Job No: *Berna, 112 Euclid*

ONE AND TWO FAMILY Soil type/Presumptive Load Value (Table R401.4.1)	PLAN REVIEW Submitted Plan	CHECKLIST Findings/Revisions/Dates
STRUCTURAL Footing Dimensions/Depth (Table R403.1 & R403.1(1), Section R403.1 & R403.1.4.1)	<i>EXIST'g Single Fram.</i>	
Foundation Drainage, Fabric, Damp proofing (Section R405 & R406)	<i>N/A</i>	
Ventilation/Access (Section R408.1 & R408.3) Crawls Space ONLY	<i>EXIST'g Gable vents w/ Soffit vents</i>	
Anchor Bolts/Straps, spacing (Section R403.1.6)	<i>N/A</i>	
Lally Column Type (Section R407)	<i>N/A</i>	
Girder & Header Spans (Table R502.5(2))	<i>N/A</i>	
Built-Up Wood Center Girder Dimension/Type	<i>N/A</i>	
Sill/Band Joist Type & Dimensions First Floor Joist Species Dimensions and Spacing (Table R502.3.1(1) & Table R502.3.1(2))	<i>2x8 16" O.C.</i>	
Second Floor Joist Species Dimensions and Spacing (Table R502.3.1(1) & Table R502.3.1(2))	<i>2x8 16" O.C.</i>	
Attic or additional Floor Joist Species Dimensions and Spacing (Table R802.4(1) and R802.4(2))	<i>N/A</i>

\* Note:  
 Rear Bedroom Windows  
 will be egress windows  
 TBD Circumvent or  
 Double Hung.  
 Section "A"  
 3/8" 1'-0"

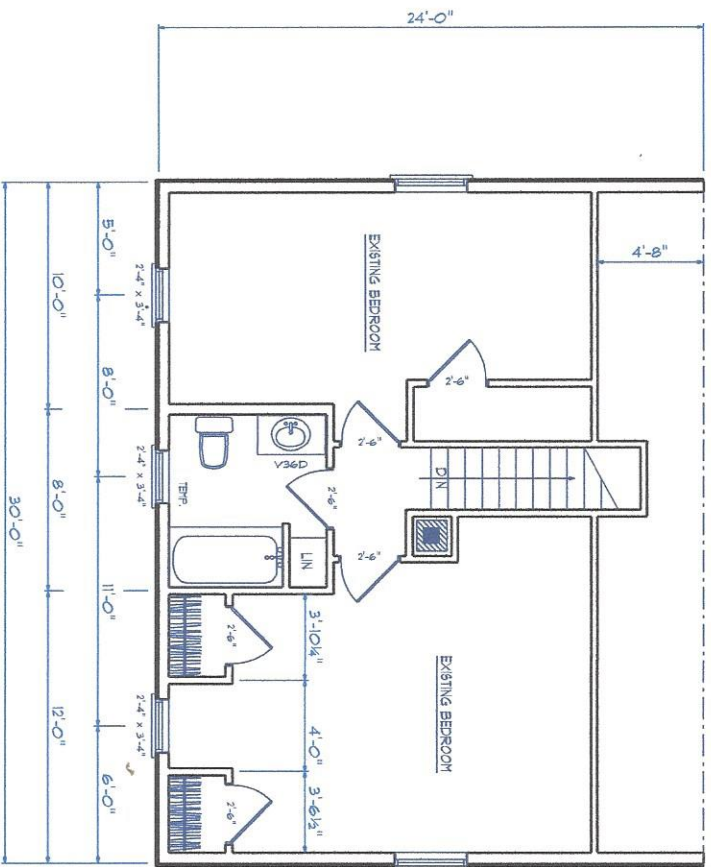
Pitch, Span, Spacing & Dimension (Table R802.5.1(1) - R 802.5.1(8))	9/12 FROST	
Roof Rafter; Framing & Connections (Section R802.3 & R802.3.1)	2.45/12 PER	
Sheathing; Floor, Wall and Roof (Table R503.2.1.1(1))	Roof 5/8 T+G Adhesive Floor 3/4" T+G Adhesive	WALLS 1/2" OSB
Fastener Schedule (Table R602.3(1) & (2))	N/A	
Private Garage (Section R302.5) Living Space (Above or beside)?		
Table R302.6		
Fire separation (Section R302.6)		
Opening Protection (Section R302.5.1)		
Emergency Escape and Rescue Openings (Section R310)		
Roof Covering (Section R905)		
Safety Glazing (Section R308)		
Attic Access (Section R807)		
Chimney Clearances/Fire Blocking (Chap. 10)		
Header Schedule (Tables R502.5(1) & (2))		
Energy Efficiency IECC, 2009 R-Factors of Walls, Floors, Ceilings, Building Envelope, U-Factor Fenestration Ventilation of Space per ASRAE 62.2, 2007
